January 25, 2022

Subject: Tide Dry Cleaners (City File No. AR DP 21-00520)
6160 Dublin Boulevard, Colorado Springs, CO
6180 Dublin Boulevard, Colorado Springs, CO (Proposed Retail / Fast Food
Building)
CEC Project 311-778

We are in receipt of your comments for this project, dated 11/10/2021. See our responses below, as well as the updated plans attached with this letter.

DRAWING NO.: **C300**
SHEET 03 OF 17

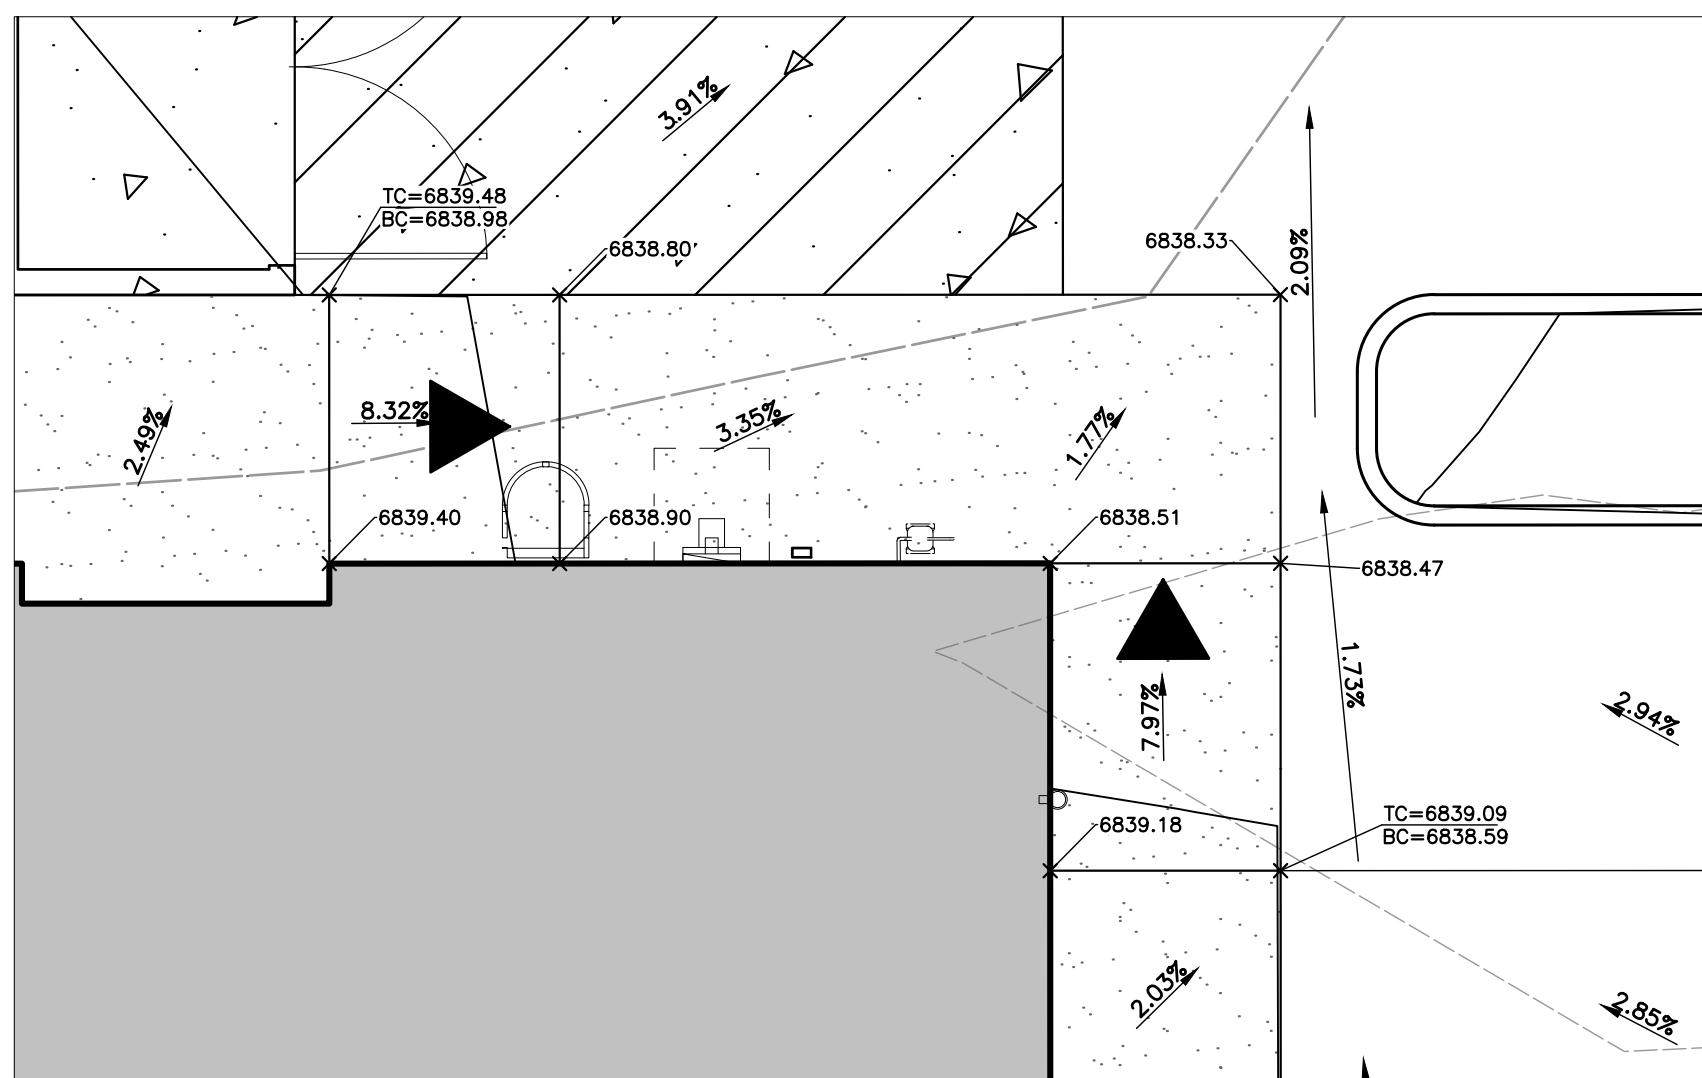
- h. Label and provide general heights for all proposed retaining walls and provide a detail. (FLP check list 18). Partly addressed – provide a detail of proposed retaining wall.

Response: The proposed retaining wall elevations have been included on sheet C300 and a retaining wall detail has been included on sheet C900

DRAWING NO.: **C500**

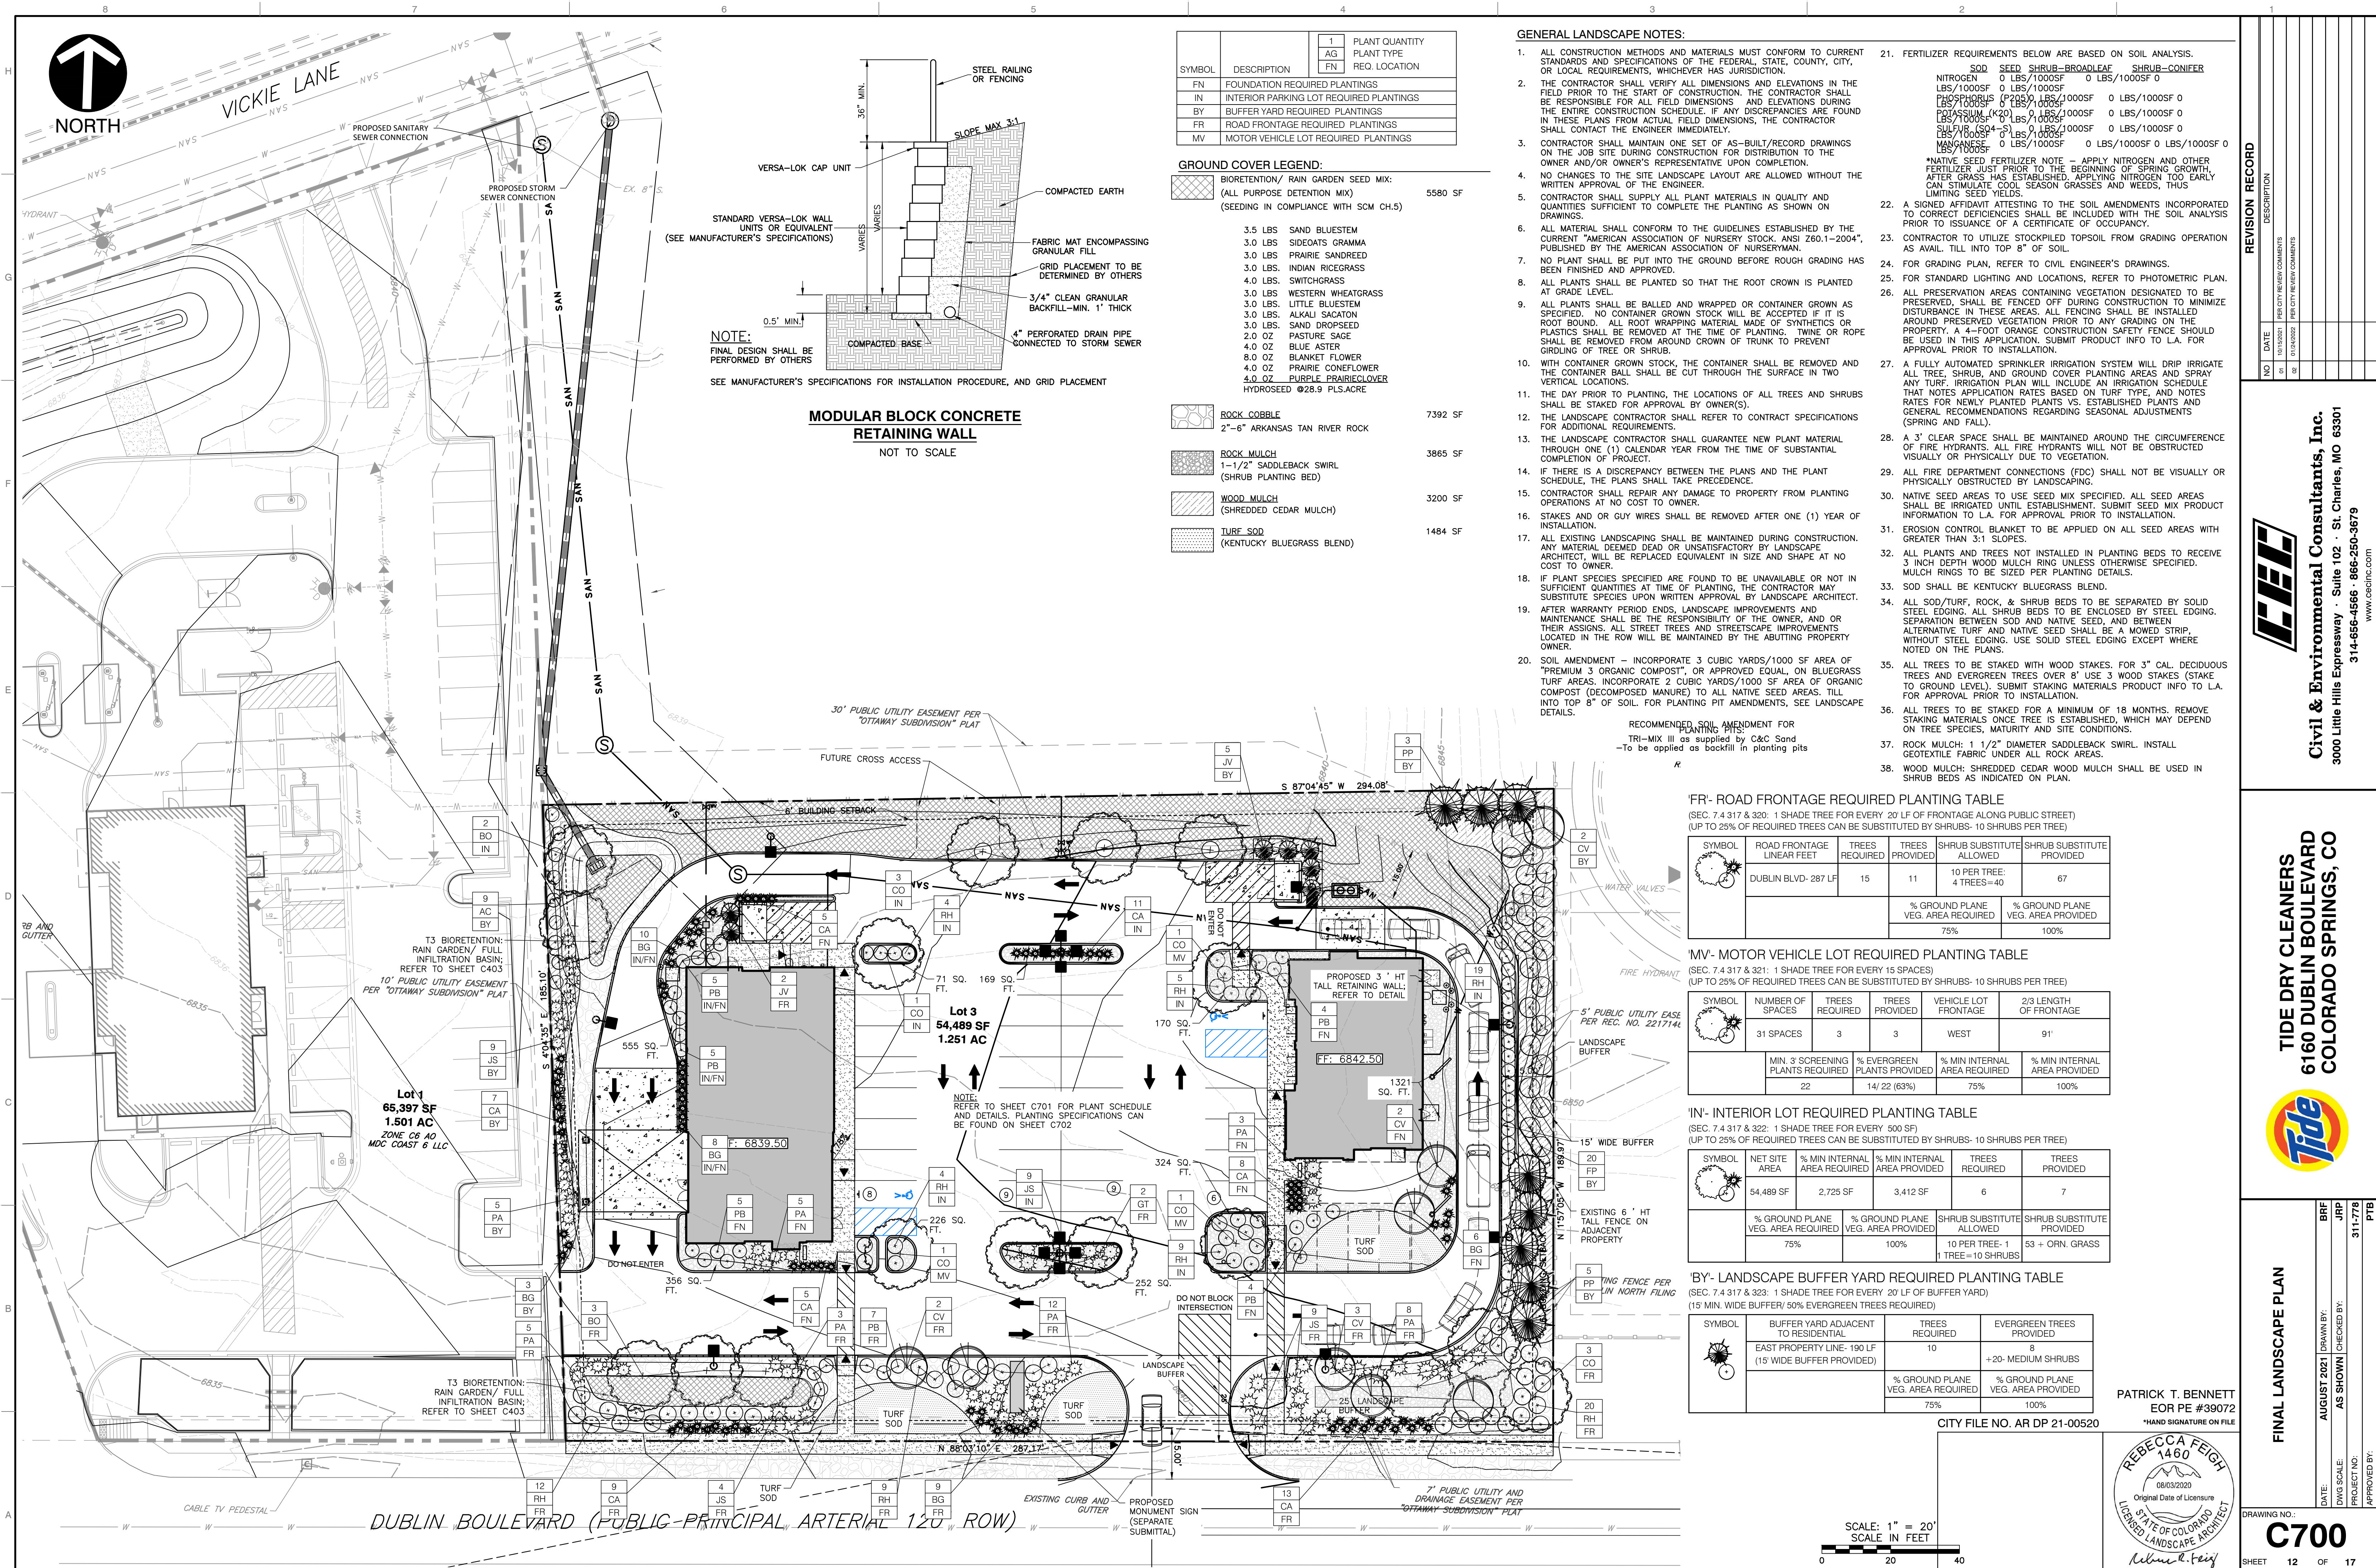
18. Regarding item 5 above:

- a. The 2” water service line for the east building cannot be PVC, please change to copper type K or HDPE.

- b. Callout the line size and material for the sanitary service line to the Tide building.

- c. The 2” water service line for the Tide building cannot be PVC, please change to copper type K or HDPE.

- d. Remove the 6” PVC fire service line callout as this line has been removed.

- e. Correct the 2” domestic water line leader to point to the water line and not the sanitary manhole.

- f. Provide the size of the hydrant lateral in the callout.

Response: The proposed water service line has been revised to HDPE, See C500

Response: The proposed sanitary service line has been labeled as requested, see C500

Response: The proposed water service line has been revised to HDPE, see C500

Response: The Fire line callout has been removed, see C500

Response: The 2” Domestic Label has been revised as requested, see C500

Response: The hydrant lateral has been labeled as 6”, see C500

DRAWING NO: **C700**  
SHEET 12 OF 17

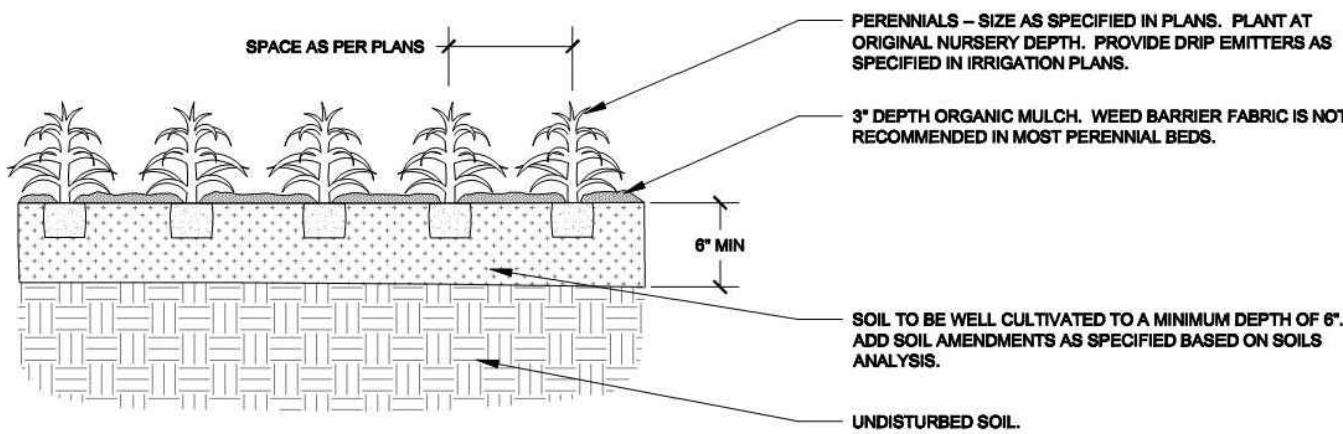
- New Comment – based on the revised plans, update the buffer requirement chart on sheet 5 and show 20 shrubs provided (currently only 14 is shown)

- d. Currently Sensation Maples are prohibited by Forestry and staff would ask to plant a different species, see the current approved street list for options - <https://coloradosprings.gov/sites/default/files/inline-images/approvedstreettreelist19.pdf>

- k. Code does not allow high water use turfgrass as an infill material and should be planned as an amenity (7.4.317.C) Staff would ask that the proposed bluegrass located along the northern property line be changed to the all purpose native seed mix shown on the plans for the detention pond area. This mix may also be used in open space areas. Update the ground cover legend (SF) and plans to reflect this. New comment – confirm all trees are meeting distance requirements from utilities, see CSU reviewer comments and revise the plans if needed.

16. Please ensure all trees are 15' away from wet mains or outside the easements (15 conflicts) and 10' away from wet services (1 conflict).

Response: The current buffer area has been updated to reflect the correct number of plants needed. Refer to sheet C700.

Response: The Maple trees have been replaced; Refer to sheet C700.

Response: The high water use turfgrass has been replaced with an all purpose native seed mix- similar to what is shown in the bioretention/ rain garden areas. Refer to sheet C700.

Response: All trees have been shifted to avoid conflicts. Refer to sheet C700.

DRAWING NO. C701

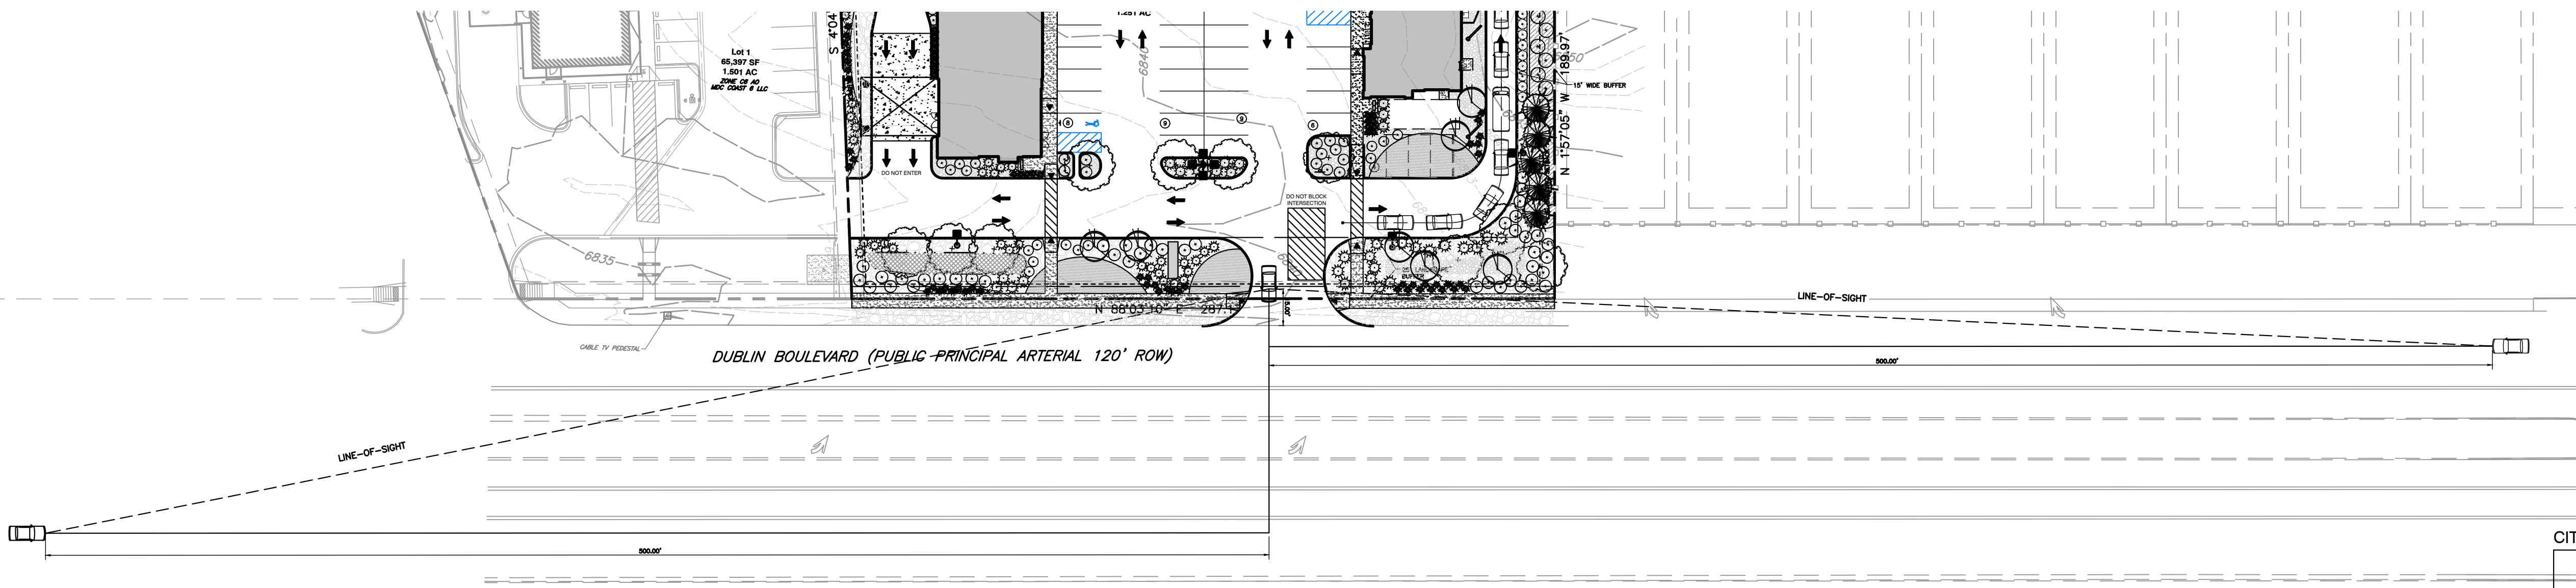
- m. Provide landscaping (fastigiated form) screening around all sides of the proposed trash enclosures (7.4.323.C.5 and H and FLP Check list #30). New comment – Move the proposed rocky mountain junipers to the shrub schedule on sheet 6 full size evergreen trees (6' tall) are not required and the smaller provided size (4'tall) meet current requirements.

Response: The Rocky Mountain Junipers have been moved to the shrub section of the plant schedule; Refer to sheet C701.
